## Subdivision Comments

From: Holly Erdman, Environmental Health Specialist

RE: LPF-21-00010 Tiger Plat

LP-08-00022

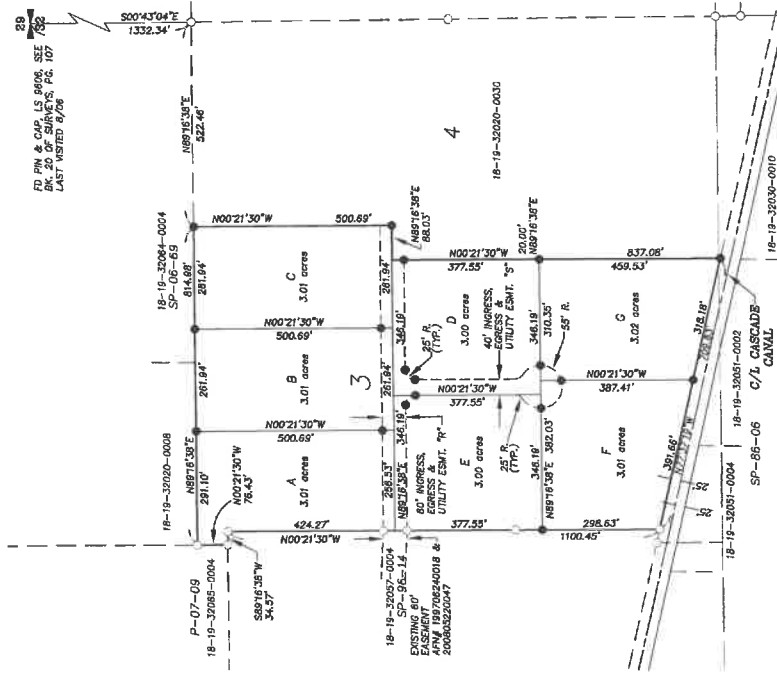
The proposed long plat indicates individual wells will be used. However, additional information indicates that 4 of the proposed lots are to be served by the Mission View Group B water system. The remaining 3 lots are proposed to be served by the Wildcat Group B water system. All wells must meet setbacks required in Kittitas County Code prior to final approval. The applicant must prove legal and physical availability of water for all new uses of water on proposed lots.

The existing Mission View Group B water system must be approved and expanded to serve 4 of the proposed lots of this plat prior to final plat signature.

The Wildcat Group B water system must have a well drilled and a Group B water system approved to be able to serve 9 connections total (3 of which are in the proposed Tiger plat) with a public water system ID# issued prior to obtaining final plat signature.
